IMT (Portland International Marine Terminal)

**RE: Portland International Marine Terminal
Existing Laydown and Connecting Corridor Connection Project
Response to Staff Comments**

RE: Site Plan Application for Portland IMT, Existing Laydown and Connecting Corridor Connection
Site Plan Addendum #4

PORTLAND INTERNATIONAL MARINE TERMINAL
EXISTING LAYDOWN AND CONNECTING CORRIDOR CONNECTION
PORTLAND
CUMBERLAND COUNTY
LANDSCAPING PLAN

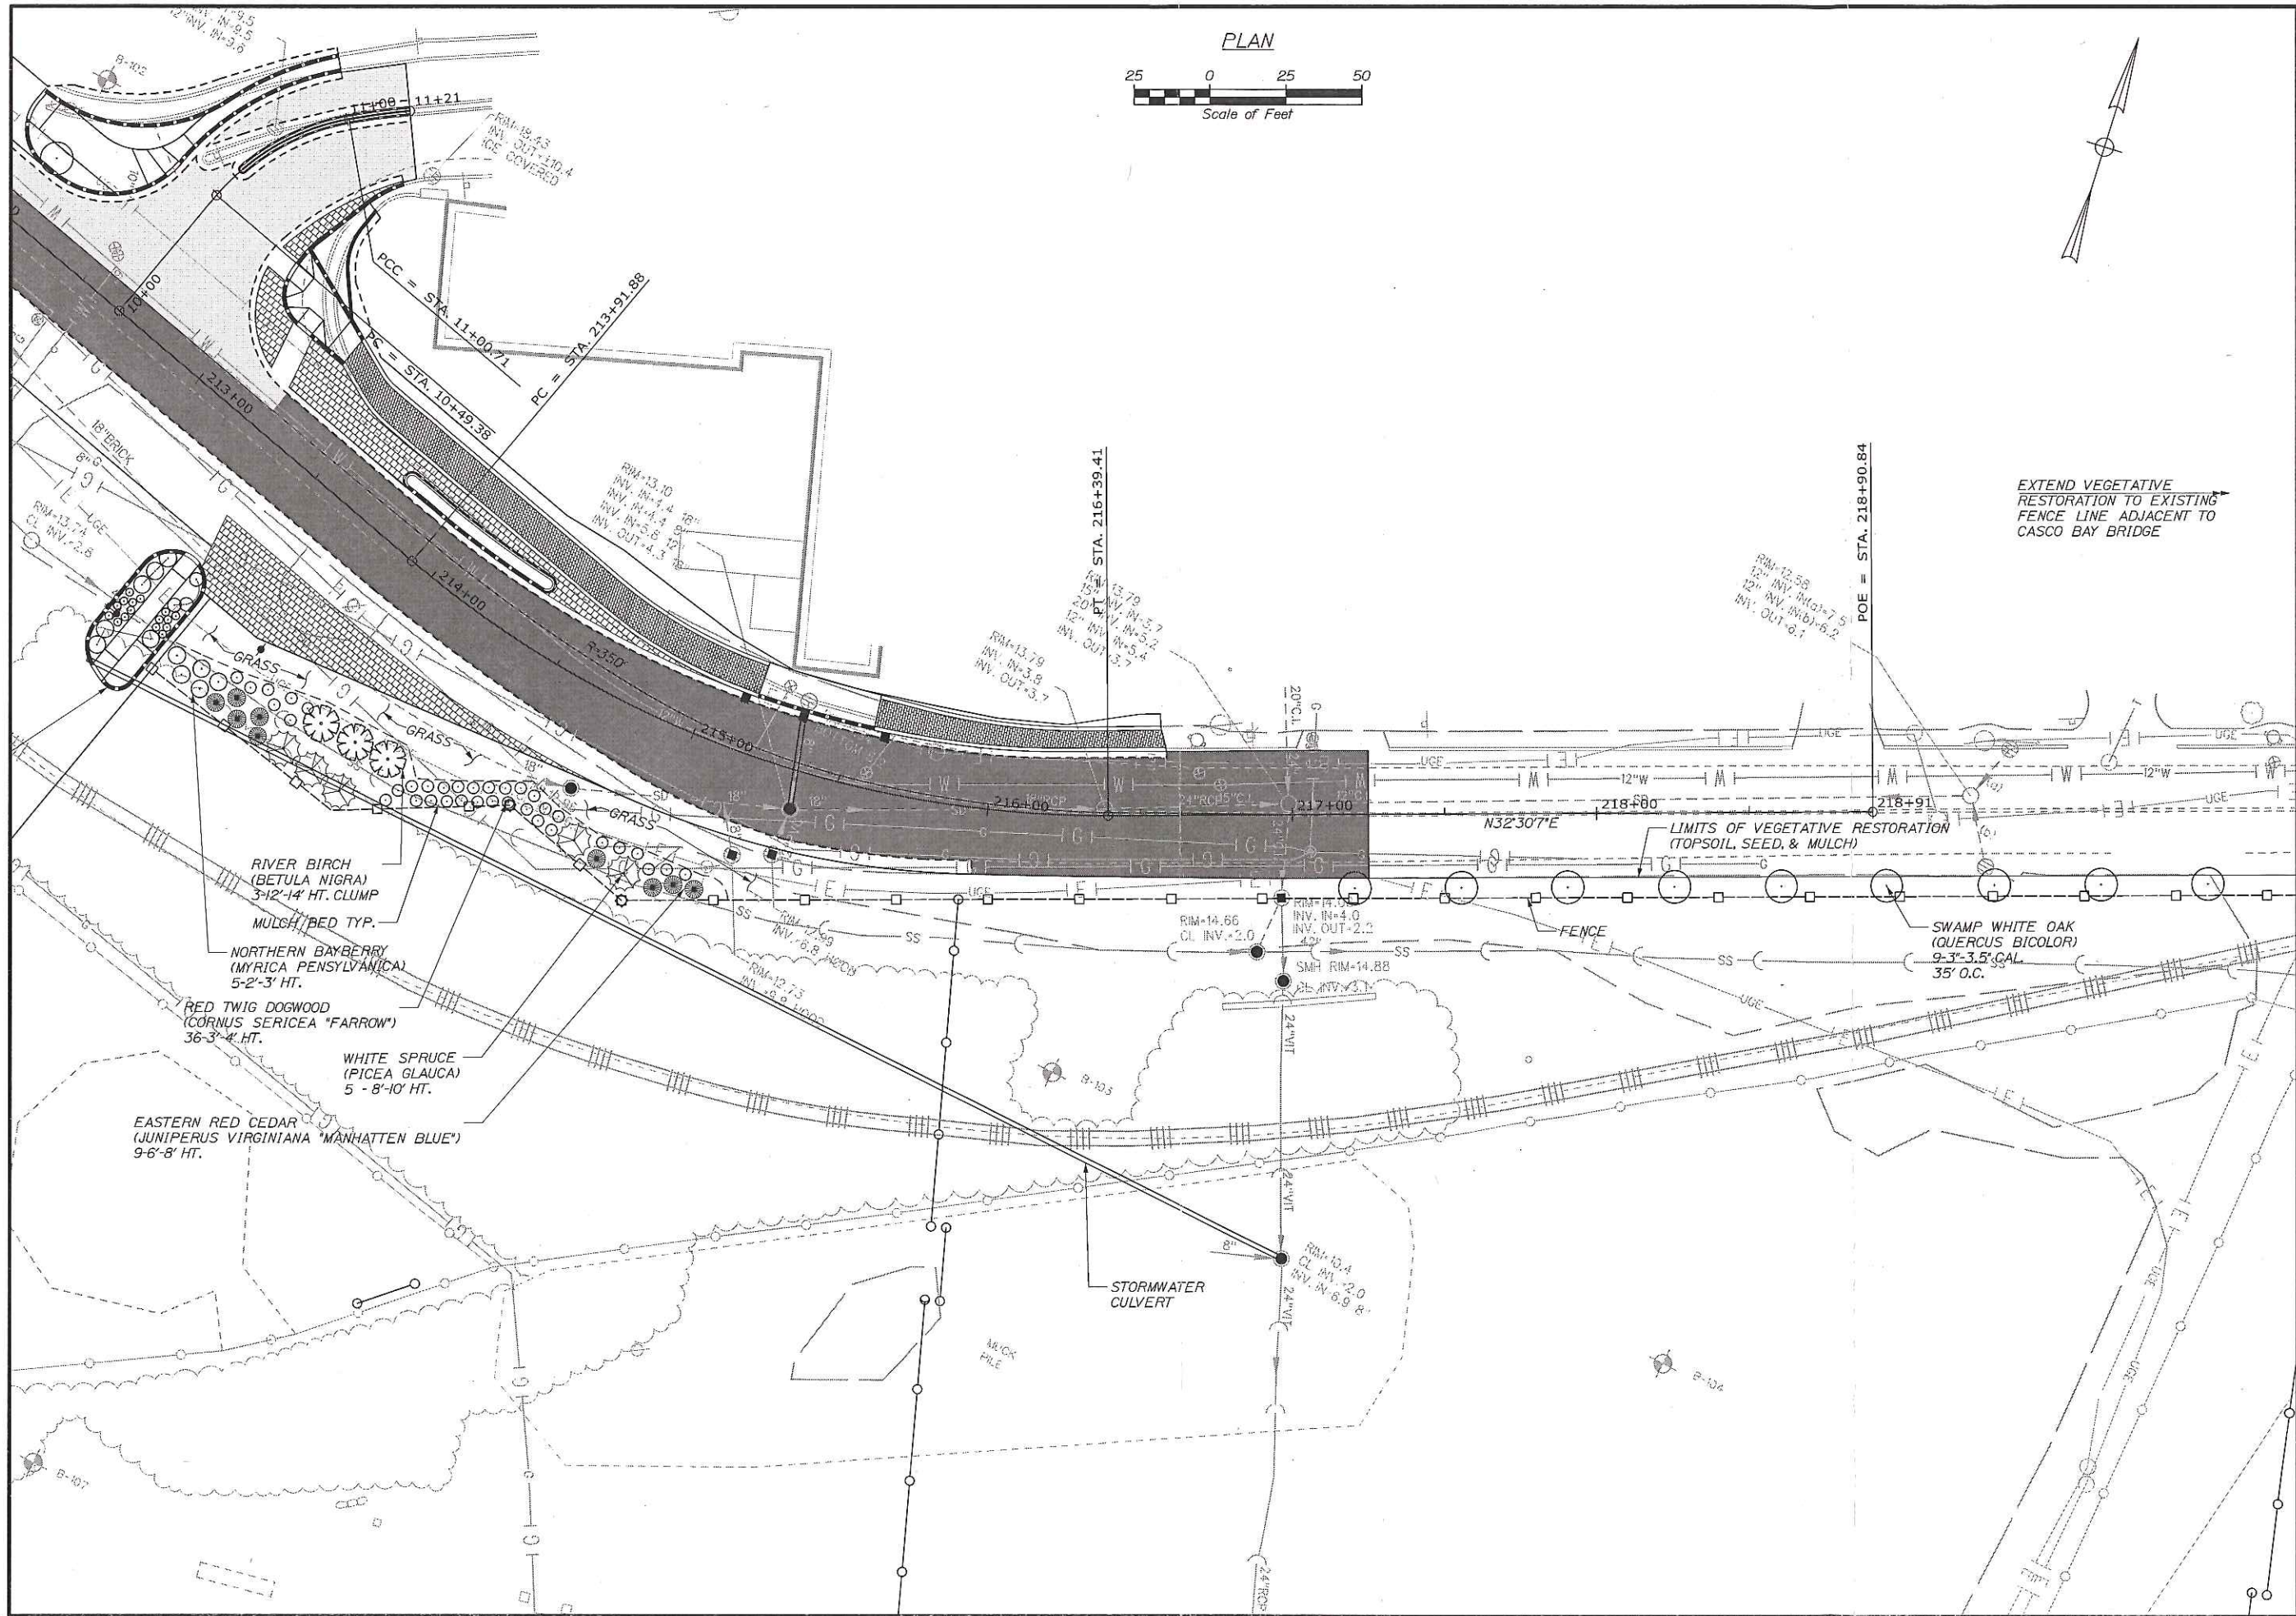
C18 Landscaping Plan - Due to the space requirements on the IMT or 'water side' of Commercial Street the project directs street tree planting across the street along an improved sidewalk and esplanade. This compromise is a fair approach given the scale of the proposed project.

Landscape mitigation of the proposed wall should be explored. Options could include: varying the wall texture or scoring so that certain length of wall panels are accentuated vs continuous the same, create pockets for vegetation, some spaces could have a grove of Bayberry, others with vines perhaps. Could local MECA be advised of possible concrete forming options with a local arts theme?

Explore fence options including using black vinyl chain link vs galvanized to reduce glare.
Unsure if barbed wire is needed?

Response: The wall has been designed with a textured surface to provide aesthetic appeal. The height of the wall has been limited to 4-ft in height in order to provide visual views of the site while maintaining the necessary safety measures against the reach stacker operations. Block-outs for vegetation will not be provided since these can act as climbing devices which negate the effectiveness of the security fence and will result in added maintenance issues (watering, care, etc.). The applicant has revised its fence type to a more aesthetically pleasing and functional palisade fence style to enhance the "gateway" appearance of the site and facilitate snow removal, while upholding the Homeland Security, MTSA 105 requirements. The fence color will be black. See Attachment E.
